RIDBC CENTRE FOR EXCELLENCE (SSD 10451) CULLODEN ROAD, MACQUARIE UNIVERSITY RESPONSE TO SUBMISSIONS

RESPONSE TO DPIE KEY ISSUES AND AGENCY AND COUNCIL SUBMISSIONS

Department of Planning, Industry & Environment Key Issues

3.4.5. CSB Courtyard

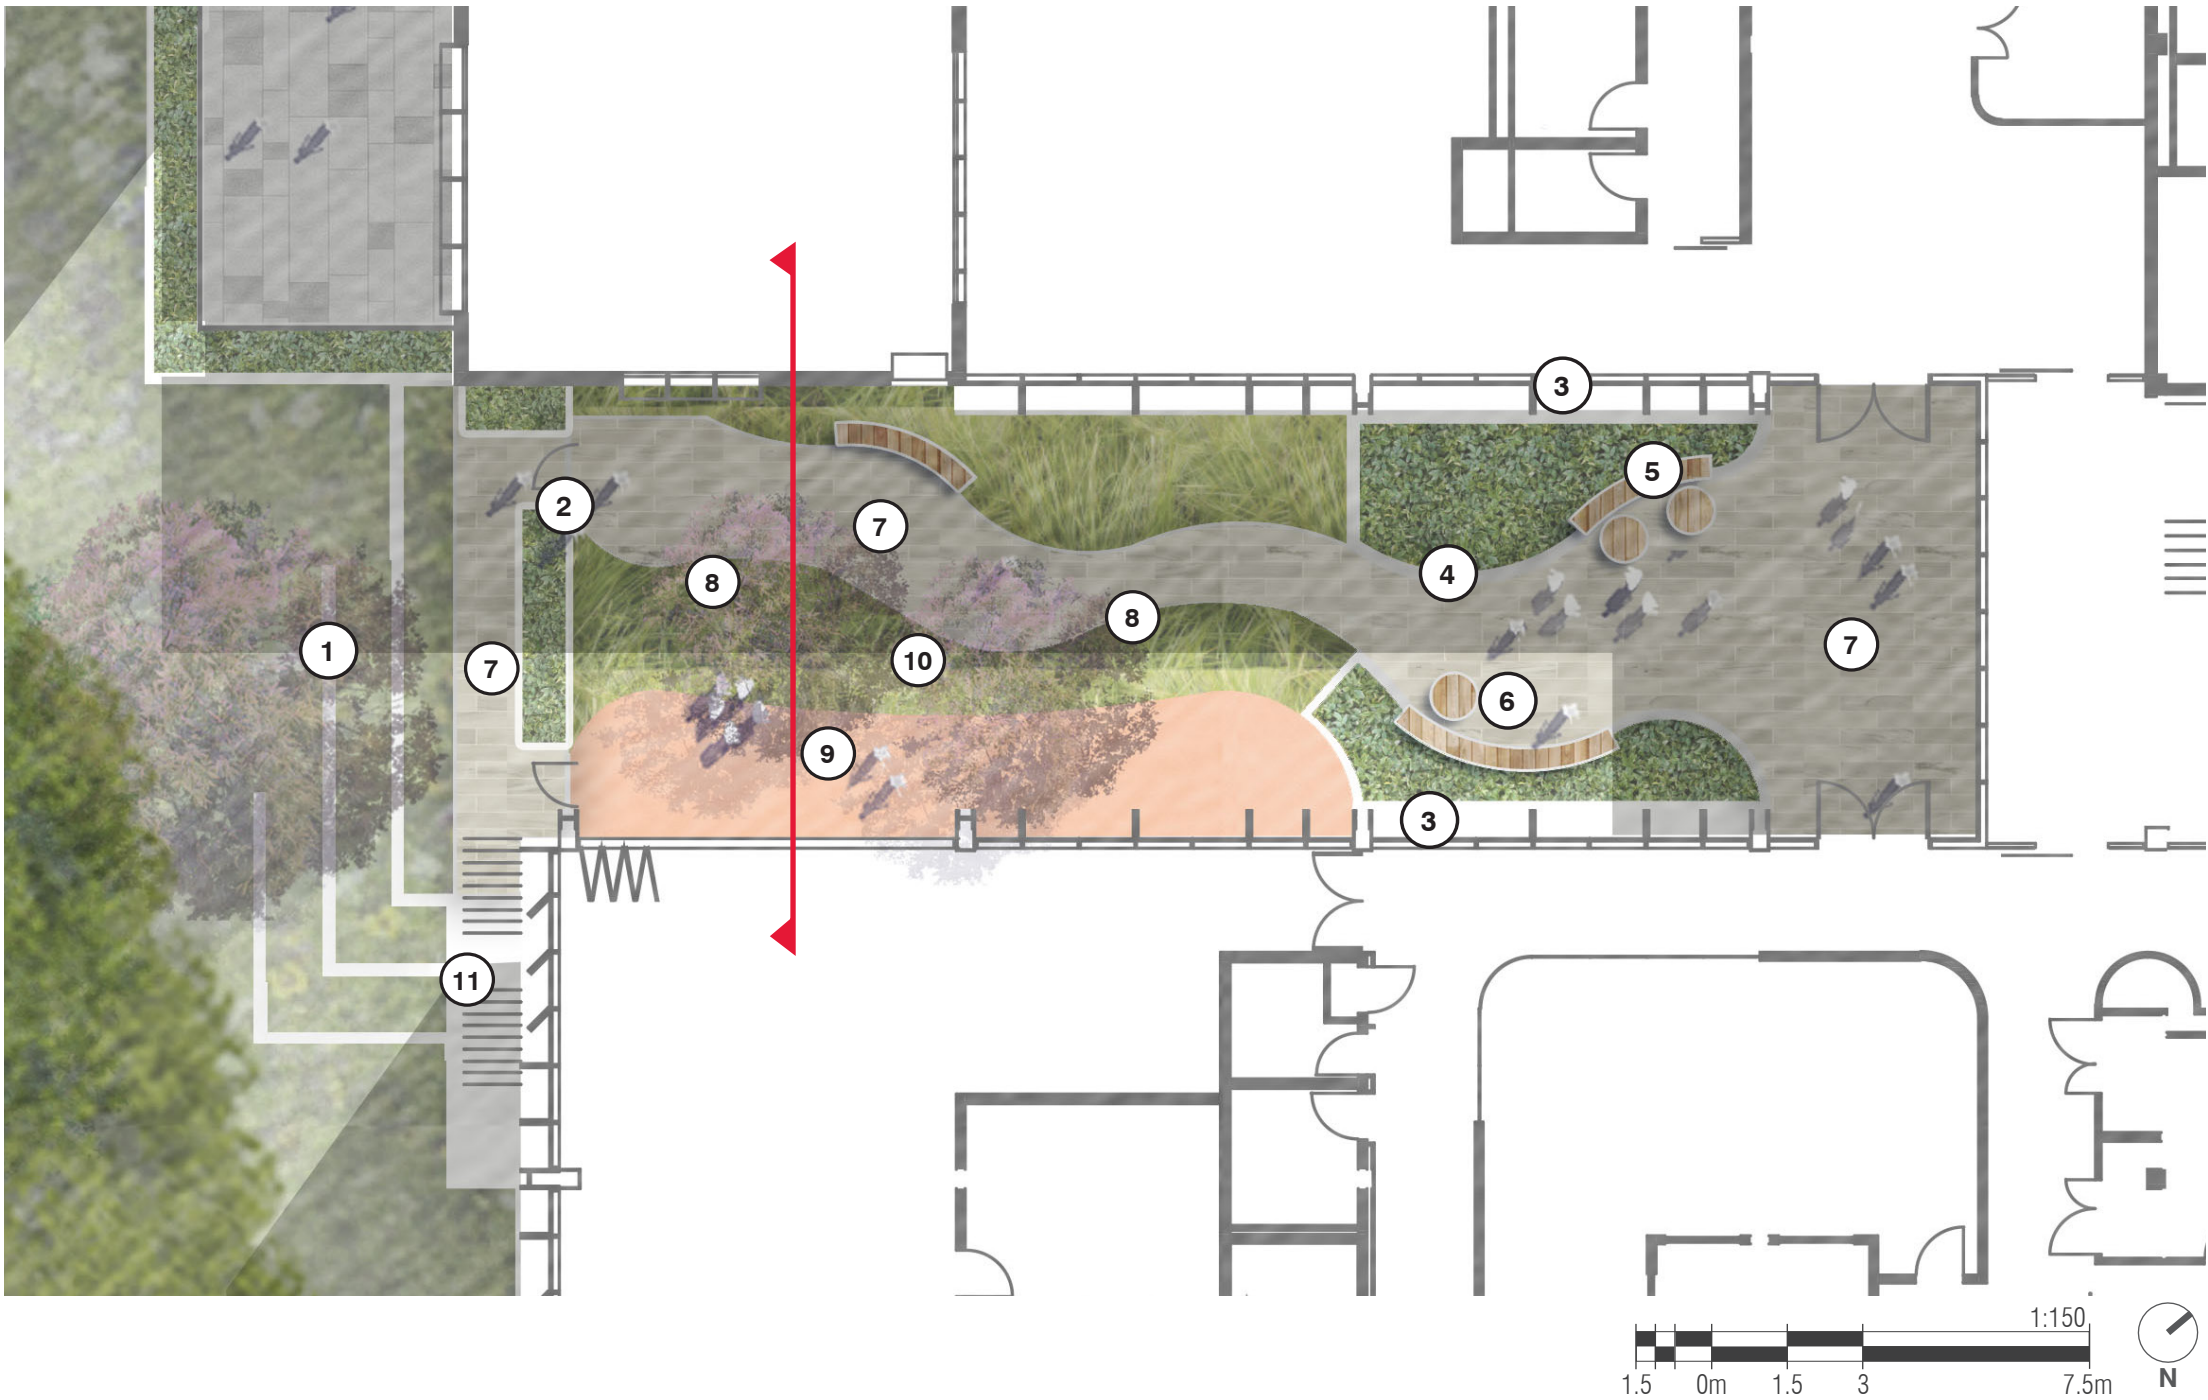
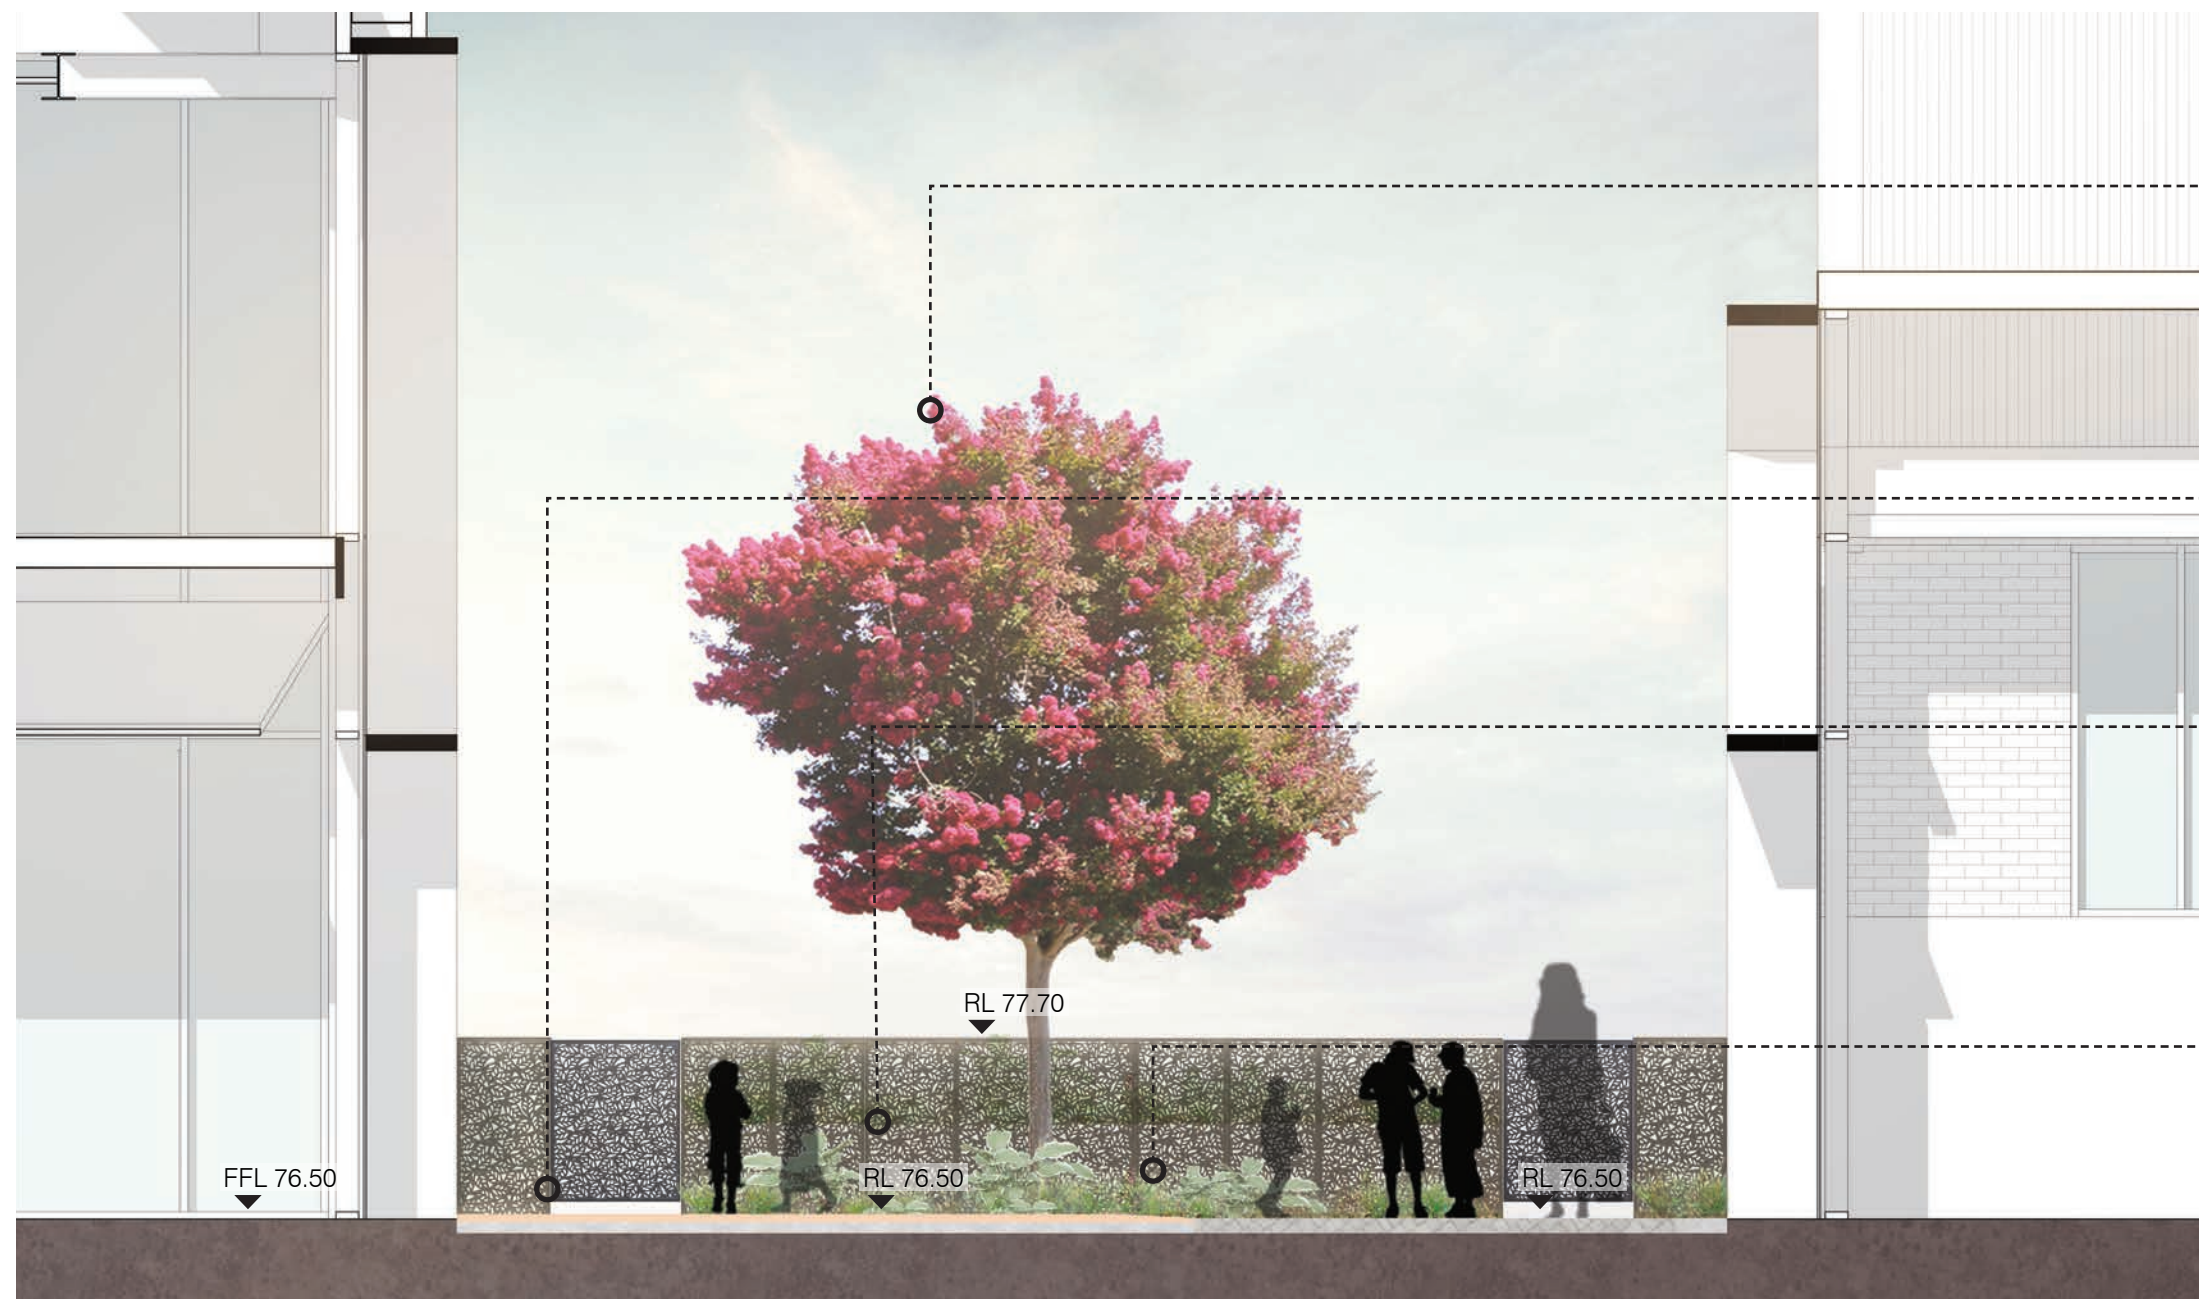
The proposed landscape strategy includes trees planted over underground structures. For example, the courtyard in the consulting building includes a feature tree (<i>Acer palmatum</i> 'Senkaki' 'Coral Bark Maple', mature size 6m x 5m) above the on-site detention tank. There are no details as to the depths of the soil for trees planted on structures. The Department requires you to provide additional information by including additional sections in the landscape plans for any planting on structures (including appropriate dimensions) to ensure soil depths are suitable for successful planting.	To address this matter, additional detail has been provided in relation to all planting on structure. This includes the CSB courtyard where an OSD tank is located underneath. The top of the tank has been shown on the relevant section and an additional drawing provided with detailed sections (L-208) showing how the top of the tank is set down 1.2m below the finished surface level of the courtyard to enable tree planting on top. Two additional drawings (L-209 & 210) have been added to show how the planters on the edge of the CSB level 1 terraces work and the soil depth provided. See Appendix E .

**Consulting Services  
Building Entry - Plan**

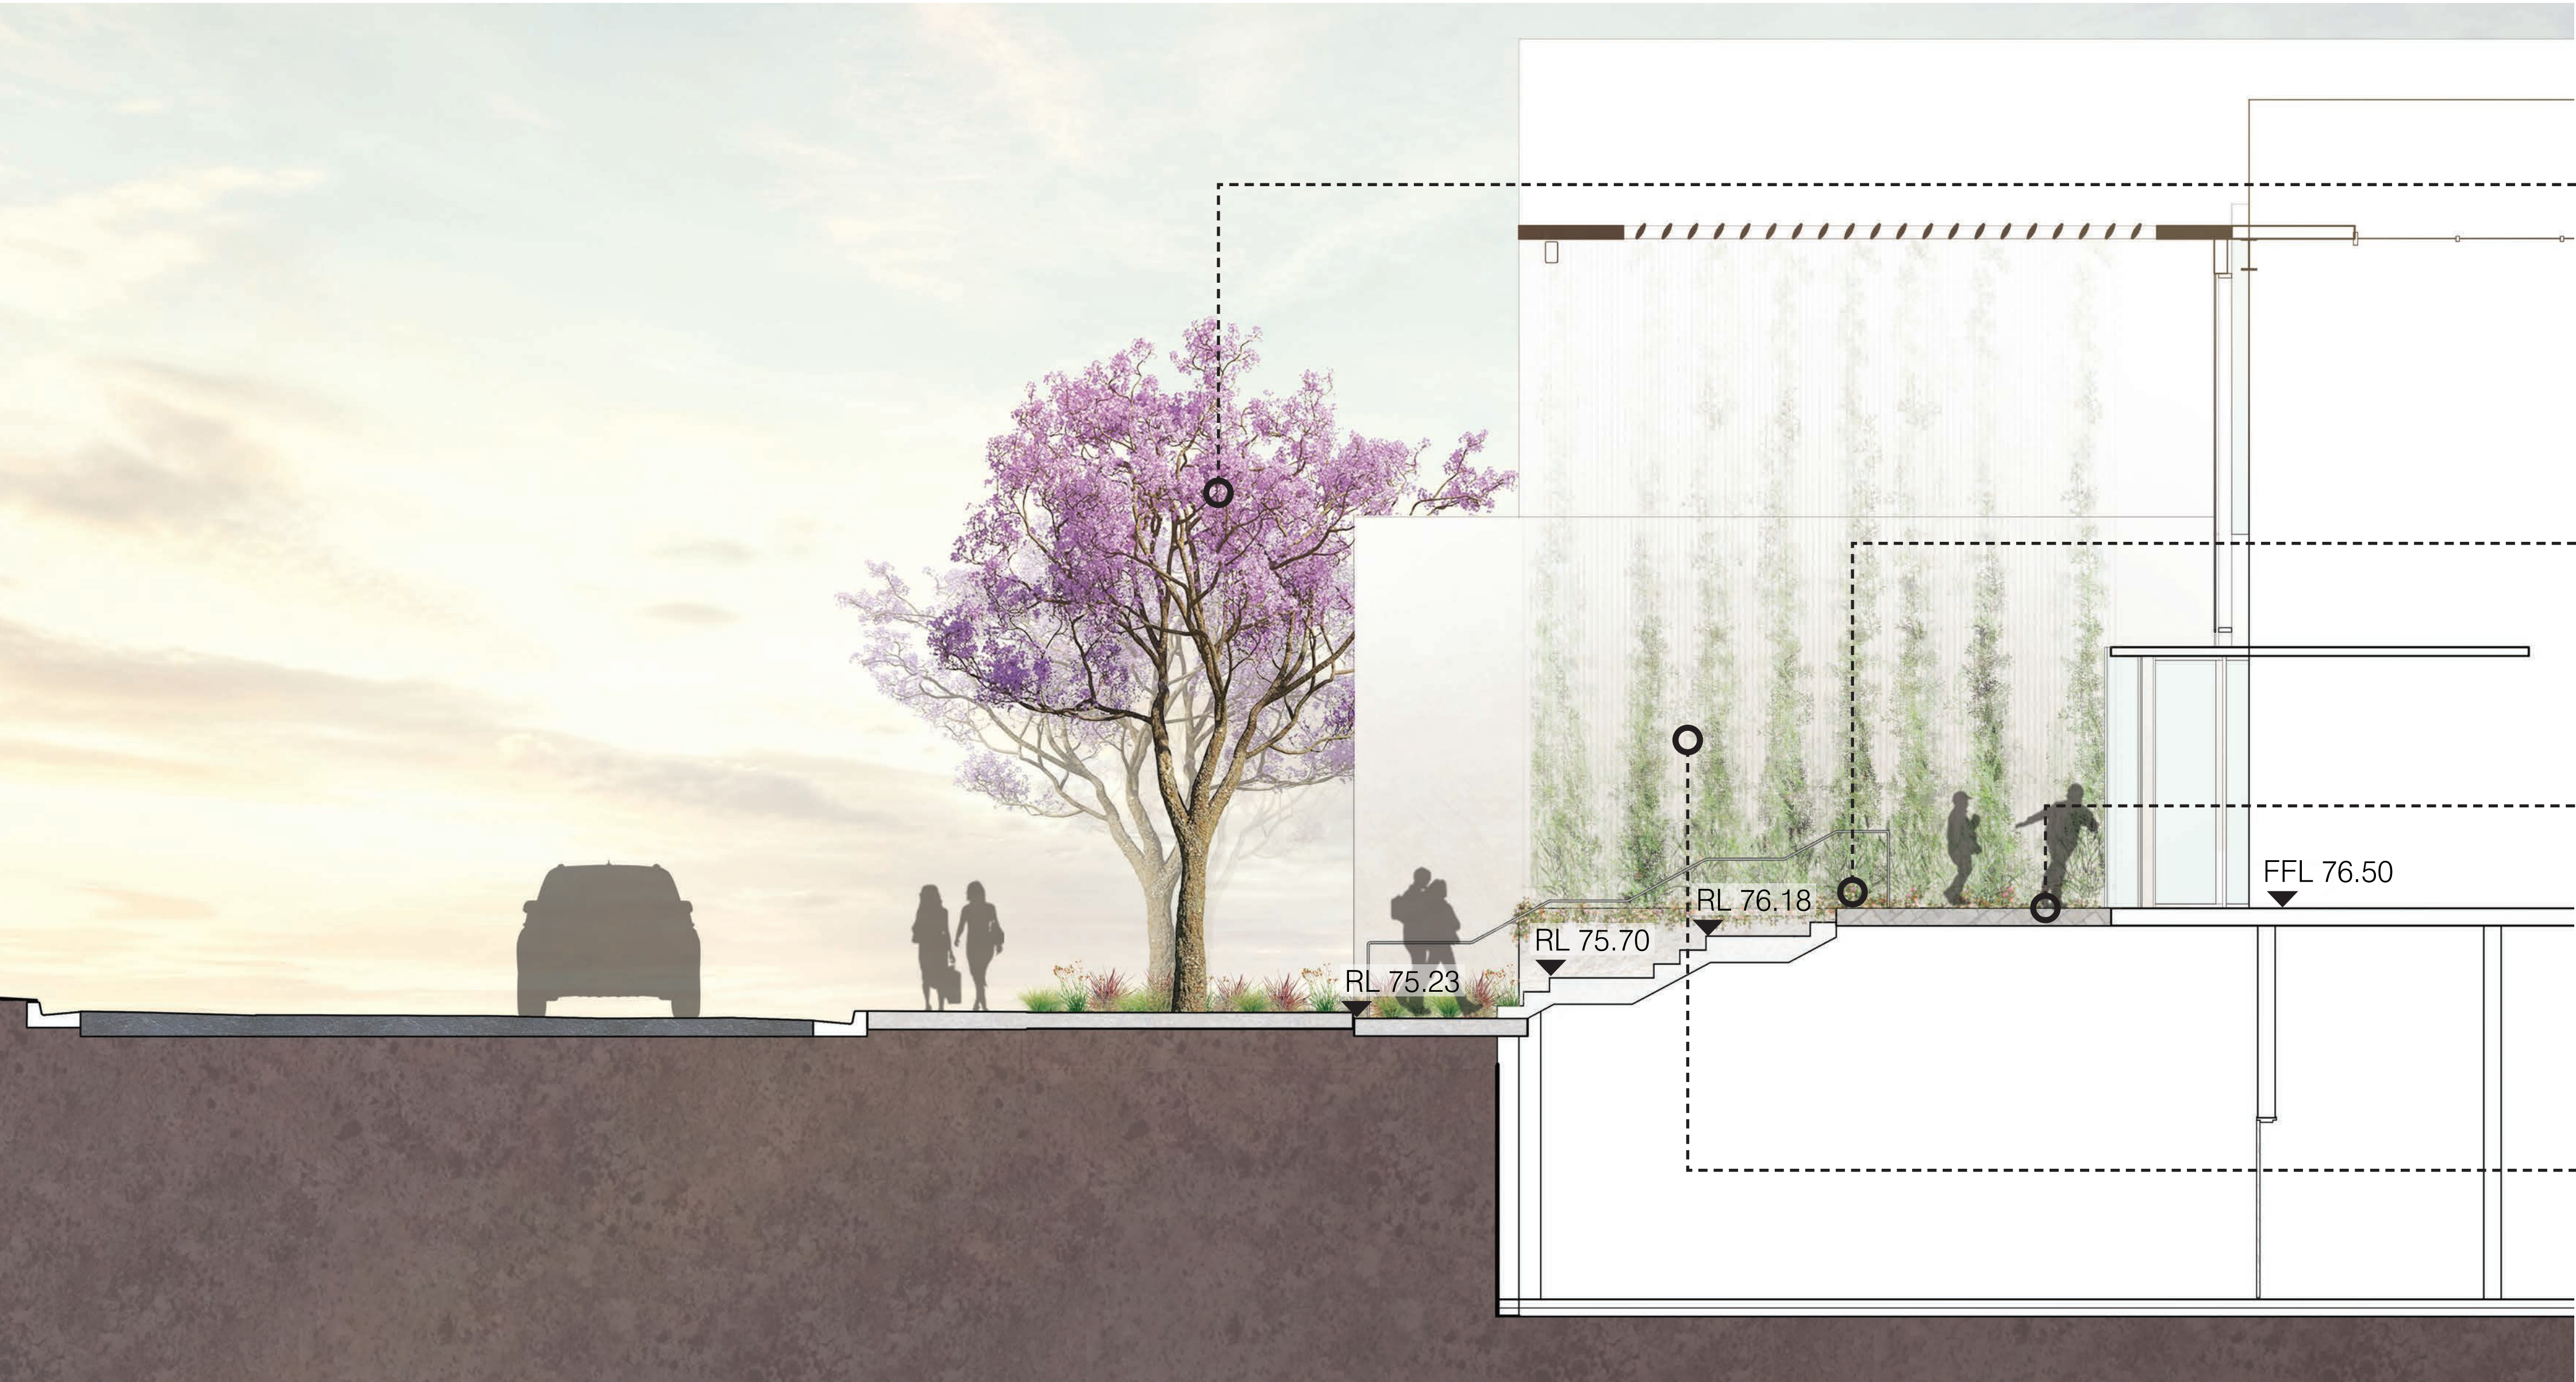
<p>The metrics relating to the vehicular arrival and drop-off sequence have been engineered to minimise the extent of the development. For this reason, structural columns are positioned at the boundary line, with the architectural response for the canopy causing a 1395mm overhang beyond the existing boundary line. This overhang is designed to further shelter students from the elements and acts to reinforce the Culloden Road streetscape and experience of the new centre through the architecture and definition of the element.</p> <p>The overhang is a direct response of the architectural and functional approaches and cannot be adjusted or moved without significant consequential impact to the streetscape, other parts of the development, or substantive preservation of the pre-existing natural amenity.</p> <p>See also pages 43-47 of the revised Architectural Design Statement which addresses the Culloden Road frontage and canopy, and design designs taken with respect to the canopy, porte cochere, and the public domain interface.</p>
